RE: Kittitas County Public Works SEPA (SE-18-00007)

SUBJECT: WDFW COMMENTS ON SE-19-00007 WEIHL ROAD IMPROVEMENT PROJECT

Exhibit 1: Wiehl Road Improvements Nearby Waterways

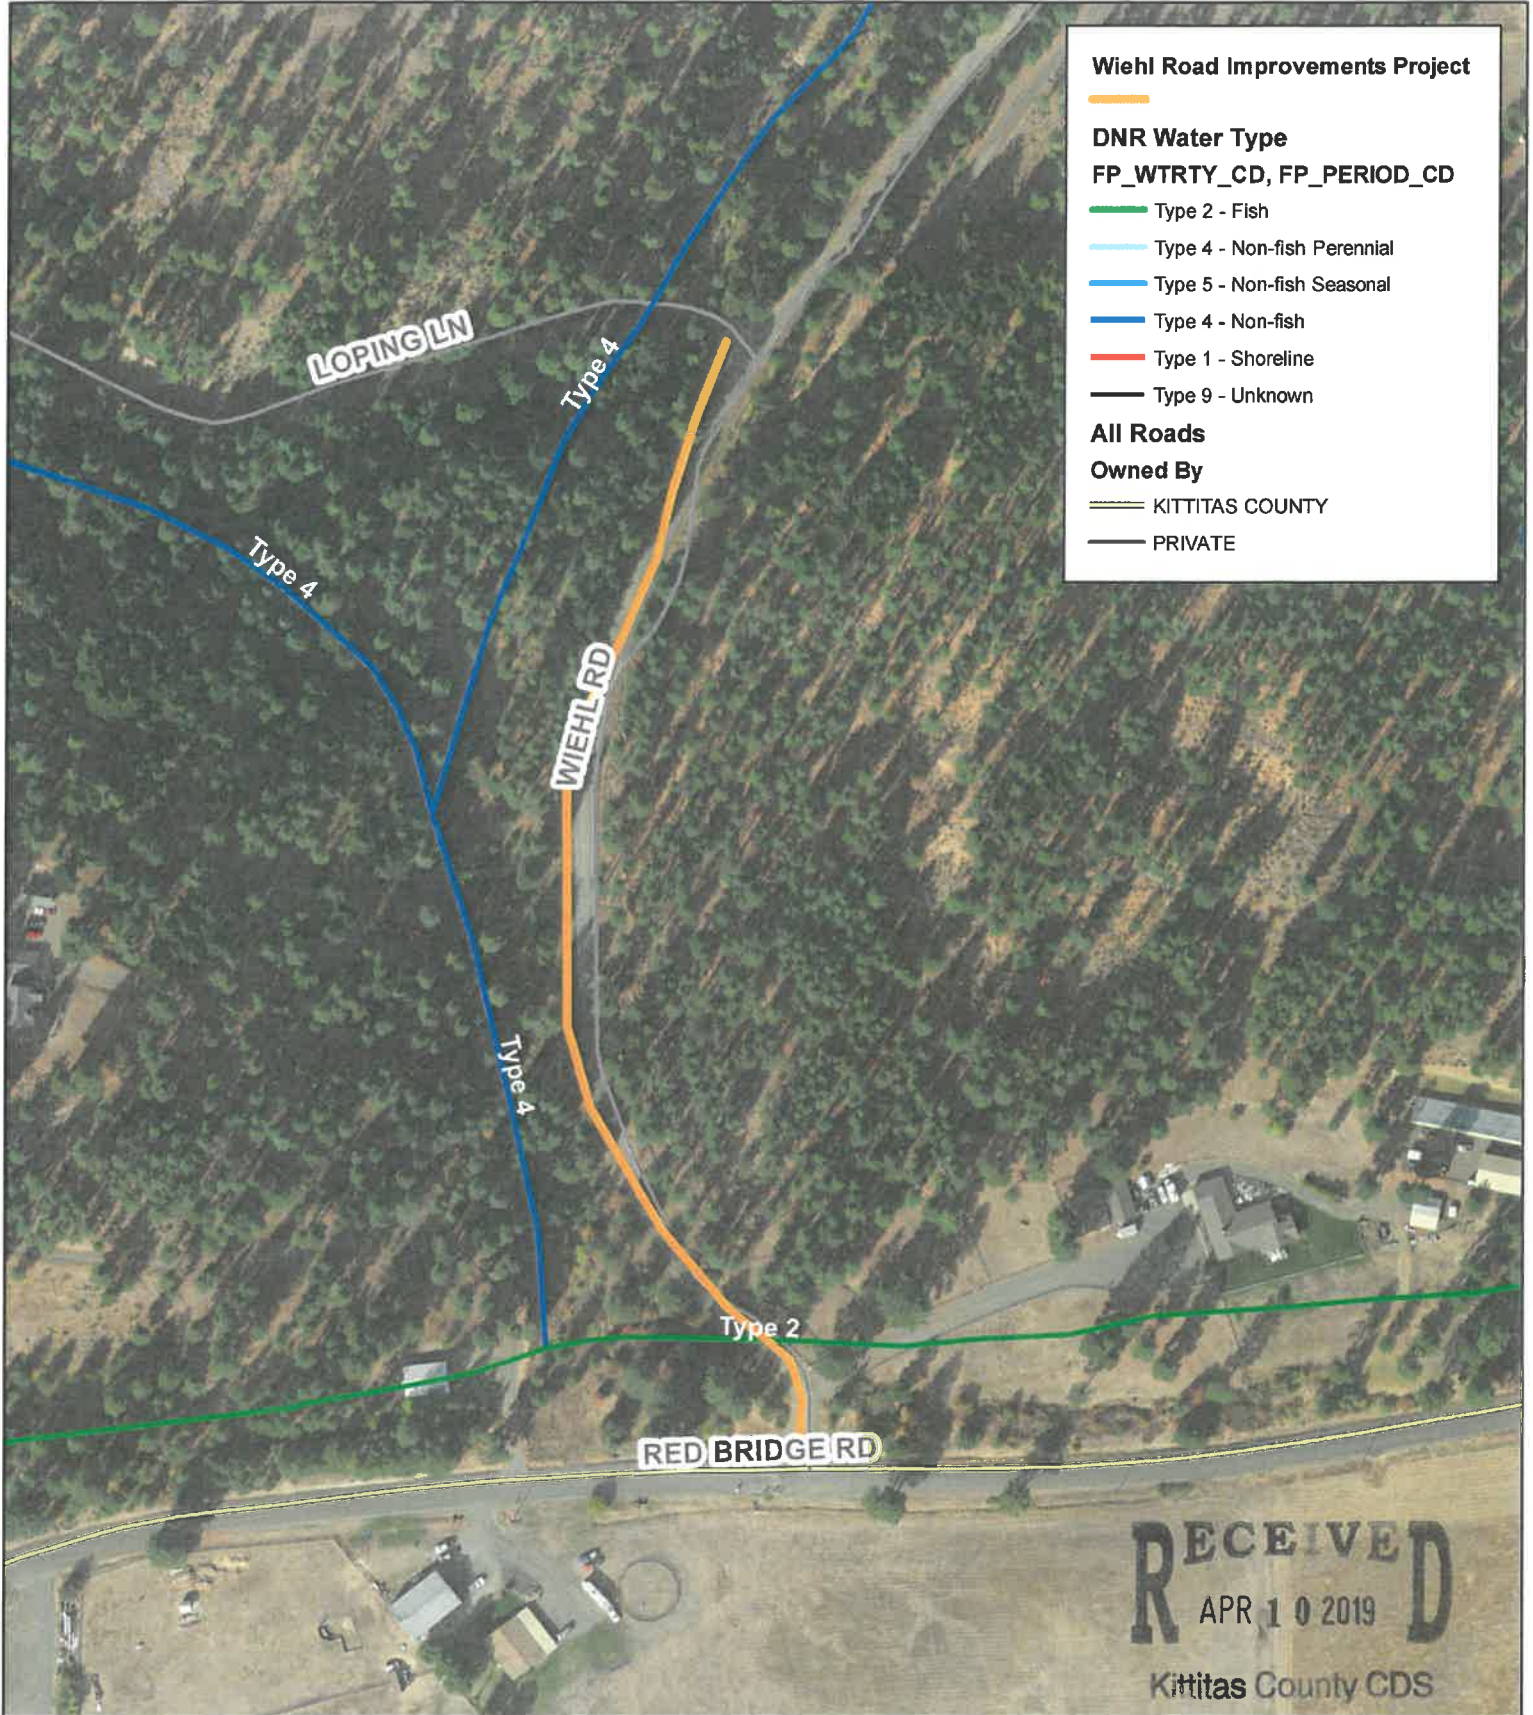
1. The attachment "PW Culvert Clarification Email, Taylor Gustafson" states that only one culvert will be replaced in this project. However, a review of the 90% submittal plan set indicates otherwise. On sheet 6, three culverts are slated for removal; on sheet 8, nine culverts are indicated for installation. Please clarify.

2. WDFW concurs that the installation of the nine culverts shown in the plan set are exempt from Hydraulic Project Approval regulation. However, we would like to offer the recommendation that you consider upsizing all culverts involved, most especially the culverts which run east-west under Weihl Road, as shown on sheets 8-11. On April 29, 2019, the single existing east-west culvert was measured as being 24" diameter. However, the plan sheet shows that the new culverts will be 18" CMP pipes, which means that the one existing pipe will be downsized. Although the number of culverts is increasing, WDFW has firsthand knowledge of the hydrology which can flow downhill towards Red Bridge Road (see Images 1-6). This information should be considered when designing and implementing the Weihl Road project.

5. The project boundary terminates immediately east of the culvert which carries the unnamed tributary beneath Loping Lane. However, we observe that this culvert is undersized (3’ diameter culvert in a 6’ bank full width channel) and perched with a plunge pool on the downstream end. This culvert should be considered for future correction.

Image 7: Example schematic of a biotechnical approach to outfall stabilization using cobbles and native shrubs.

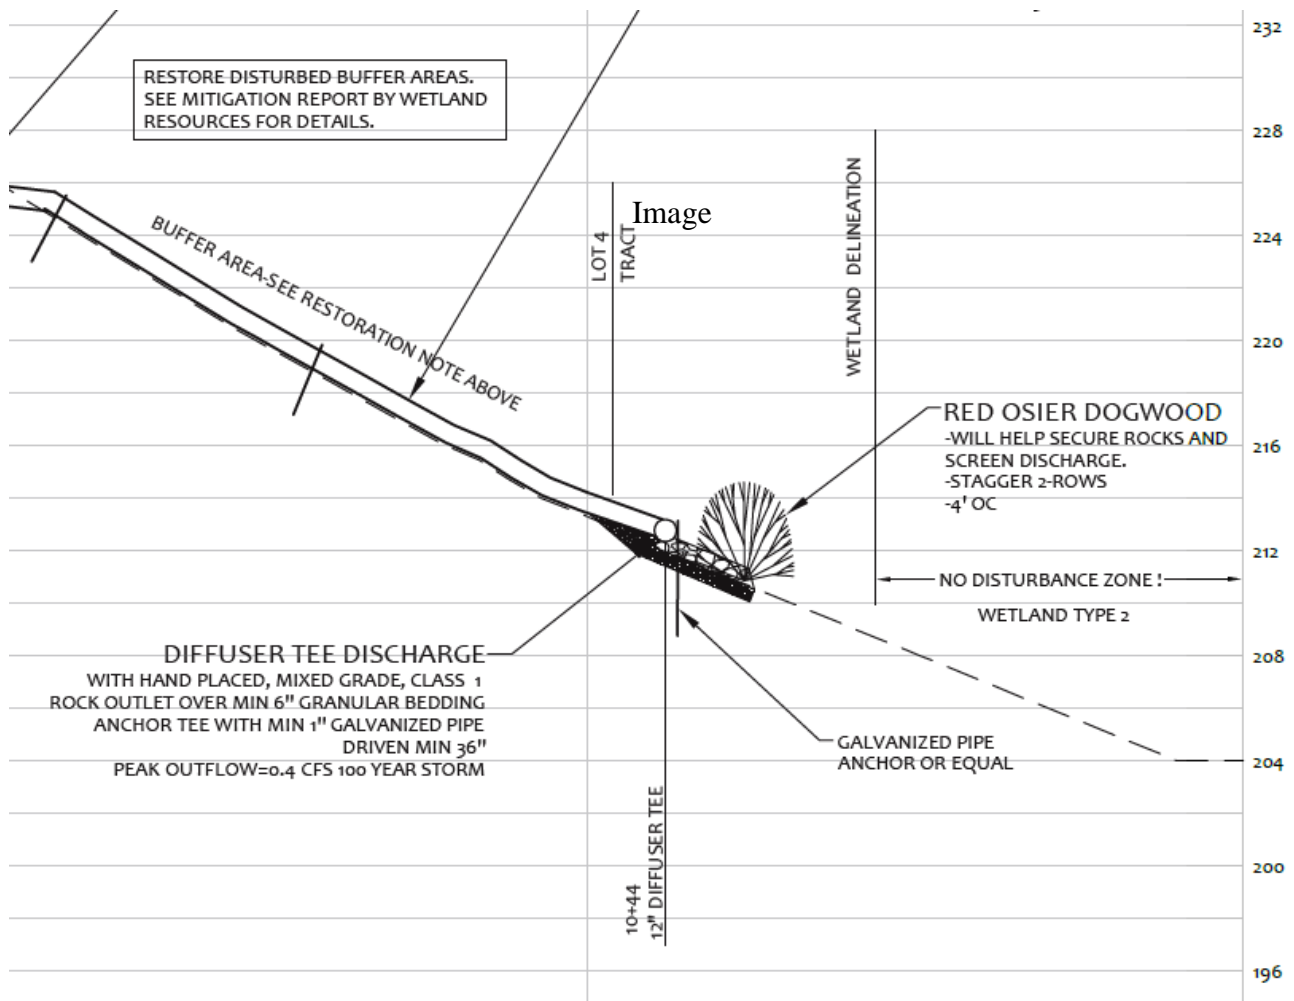
3. We recommend that you utilize biotechnical soil stabilization techniques at the base of the east-west culverts where they emerge from the welded wire wall. The flow which will empty from these culverts has the potential to erode the ground at the base of the proposed wall. On sheet 5,

under “Culvert Detail”, quarry spalls are shown for placement beneath the installed culverts. However, we recommend placing a geotextile fabric square, covered with rounded cobbles and planted with willow or dogwood stakes, beneath the outfall of the culverts (see Image 7). This technique has been used to great success in preventing erosion on slopes which are subject to overland, non-channelized flow.
